Engineers Comments Regarding Surface Water Drainage

Application Reference:	R/20/24/DOC	Reviewer Reference:	ADC/EXT2/D2134/40
Planning Officer:	Kathryn Welch	Date of Review:	28.10.2024
Site Name:	Rustington Convalescent Home Sea Road Rustington BN16 2LZ		
Application Description:	Approval of details reserved by condition imposed under R/258/18/PL relating to condition 19-foul and surface water sewerage disposal.		
Assessment Number:	1 of 2

Application Reference: R/20/24/DOC	Initial Issue Date: 28.10.2024
Site Name: Rustington Convalescent Home Sea Road Rustington BN16 2LZ	Issue Date: 28.10.2024
	Reviewer Reference: ADC/EXT2/D2134/40

Job Title		SEA ROAD RUSTINGTON, WEST SUSSEX	
Drawing Title		DRAINAGE LAYOUT SHEET 1 OF 3	
Client		MACAR HOMES (RUSTINGTON) LTD	
Scale	Date	Designed	AK
1:200 @A1	MAY 25		
Drawn	Checked	Approved	BAC
AK	BAC		
Job No	Drawing No	Rev	
25-043	25-043-105	B

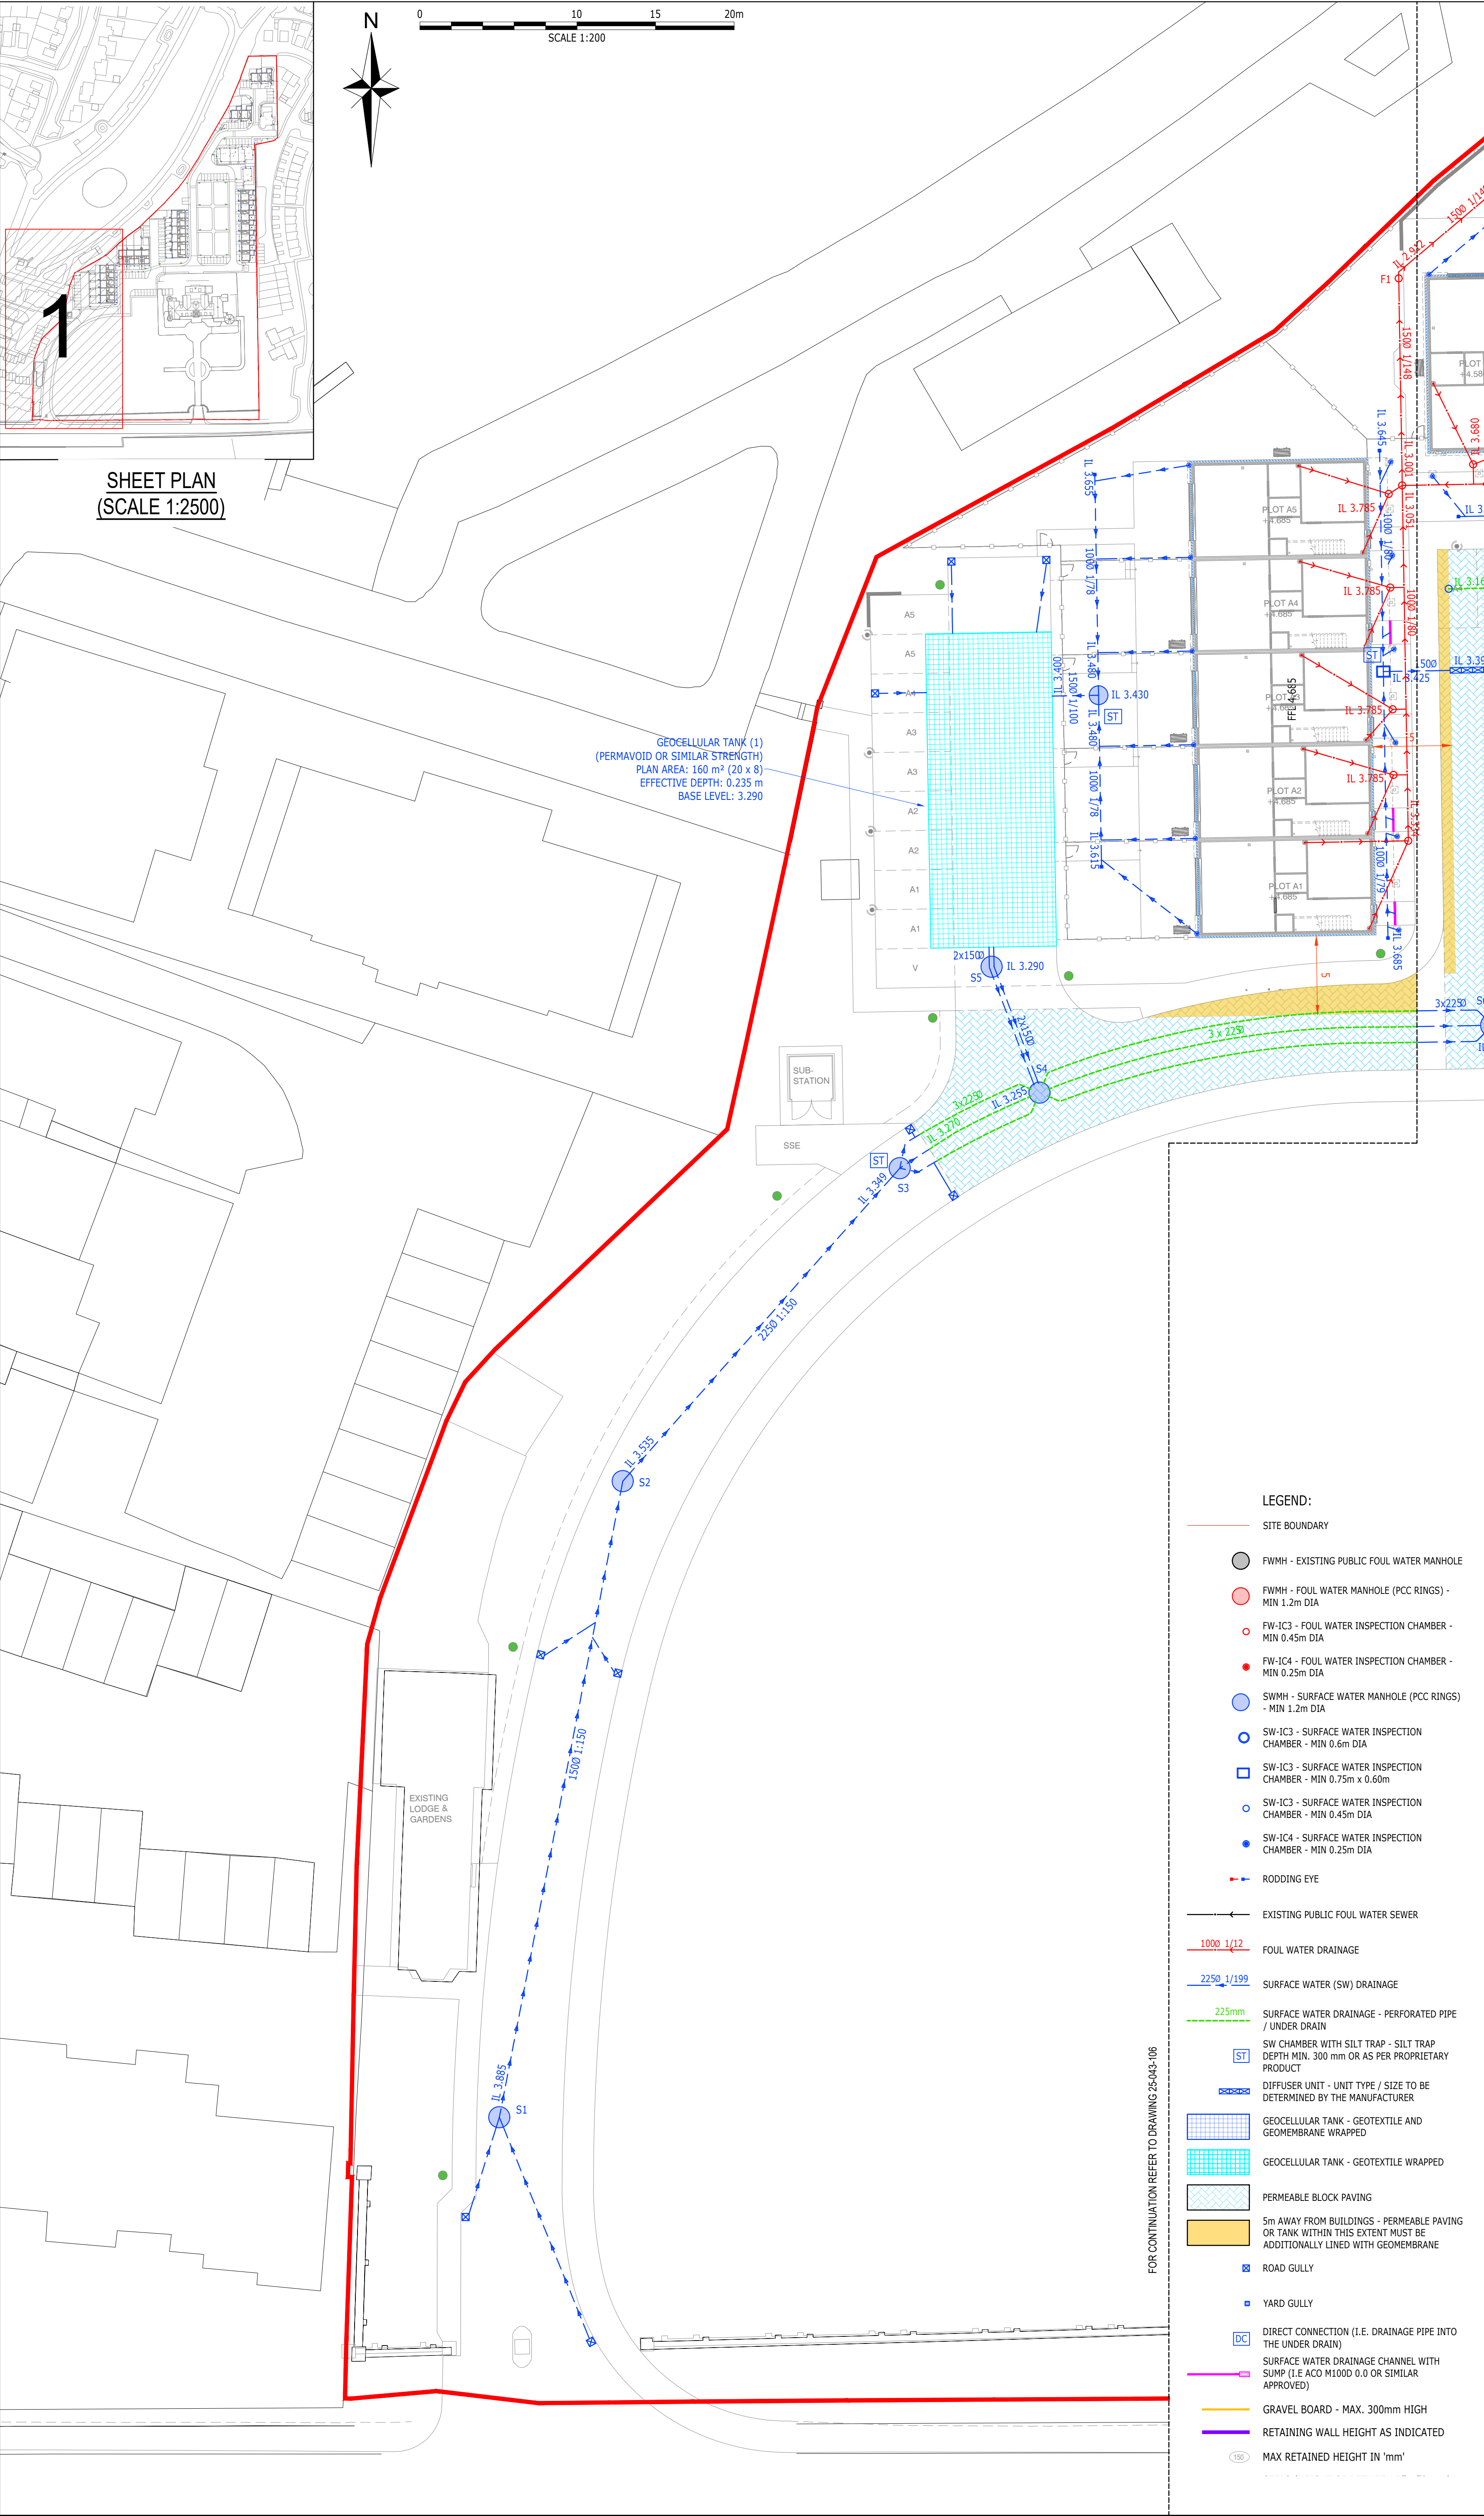
5.	Groundwater monitoring has been undertaken over the winter period. This appears to have some tidal influence with a seasonal peak of the order of 1.9m AOD. In light of the above compliance with the EA guidance in providing a 1.0m freeboard between the base of an infiltration feature and seasonal peak groundwater level it remains unclear if the	See included drawings and calculations.	No further evidence has been provided in respect of groundwater and the response to this comment is inadequate. Drainage strategy drawings 1,2,3 do not include any reference to groundwater and freeboard to all SUDS features. Comment outstanding.	Please see Odyssey drawings 24-059-105, 106 and 107 which indicate the location of groundwater (GW) monitoring locations and highest recorded level. Proposed infiltration features have their base level located above the highest recorded GW levels at the appropriate locations.	No further evidence has been provided in respect of groundwater and the response to this comment is inadequate. Whilst drainage layout drawings 105,106,107,108 annotate all geotechnical testing locations with groundwater levels, however numerous

permeable pavement depth / formation level comply. Section 4.0 suggests a formation of 2.383m AOD (zone 9) which would inform a freeboard of 480mm; this does not comply with ADC standing advice. Furthermore it has been acknowledged there is a tidal impact here so it is considered a suitable freeboard is essential for the design life of the site when factoring in sea level rise.				permeable pavement depths appears to sit below the peak groundwater datum. It is evident there does not appear to be any freeboard between any SUDS feature 'base' and 'peak GW' and the permeable pavement depths are variable. It remains unclear if the designer has made allowances for saturated storage. Comment outstanding.

9.	Permeable pavement formation levels must be annotated.	Base levels are shown on the Drainage strategy.	Base level appears to be either 2.88 or 2.87; which is correct? It is noted that the permeable sub-base formation is intended to be flat, therefore depths are varied to form the final profile. In some areas depths are noted in excess of 1.44m however Sketch drawing 008 illustrating the stand detail does not qualify the greater depths and if geogrid will be required. Bespoke construction details must be provided for all SUDS features; for permeable pavements any check dams,	Please see Odyssey drawings 24-059-105, 106 and 107 which indicate sub-base levels for permeable paving at the start and end of respective sections. Please note that for permeable paving where infiltration is used the base is assumed as flat. For permeable paving sections where their main purpose is to convey water (to sections that infiltrate) the levels are provided for the sub-base at its upstream and downstream extent with the constant gradient in between. The thickness of sub-base is not	Base level appear to vary across the site hence this is a complex solution. It is noted that the permeable sub-base formations are mixed being flat and sloped and the depths are variable The permeable details on drawing 123 are too generic and do not reflect the greater depths and if geogrid/structural support will be required.

finish information is also supplied.				
11.			Further construction details of TANK 3 are require to appropriately demonstrate how this will be installed underneath a permeable pavement.	Refer to Odyssey drawing 24-059-111 for details of the tank. The water would permeate through the permeable paving structure and then flow into the tank via the geotextile.	Generic details are not accepted. Further construction details of all SUDS features are require to appropriately demonstrate how this will be installed underneath variable finishes.
12.					Further construction details of all SUDS features are require to appropriately demonstrate how this will be installed underneath variable finishes.
13.					Cross sections are require where there are split permeable paving types and underdrains.
14.					What is the size and shape of geocellular tanks 5 & 6;this appears to be

amorphous hence unbuildable?
15.					Diffuser used for infiltration must be located at least 5m from any structure.
	Hydraulic Calculations:				
16.	The 1D model must include a supporting plan to denote all nodes/links or cascade approach.	See Drawings.	The drainage strategy plans and Infodrainage calculations do not tally. There are numerous catchment areas not identified on any plans. Comment outstanding.	Refer to Infodrainage calculations '24-059 - Rustington, Sea Road_SW system' including the catchment plan which provides the requested information.	The drainage strategy plans and Infodrainage calculations do not tally. There are numerous catchment areas not identified on any plans. Comment outstanding.

24.	Permeable paving diffusers need to be included.	See Drainage Strategy drawings.	Noted, these are shown on the drawings, however there	The drainage details indicate the locations of the	Noted.
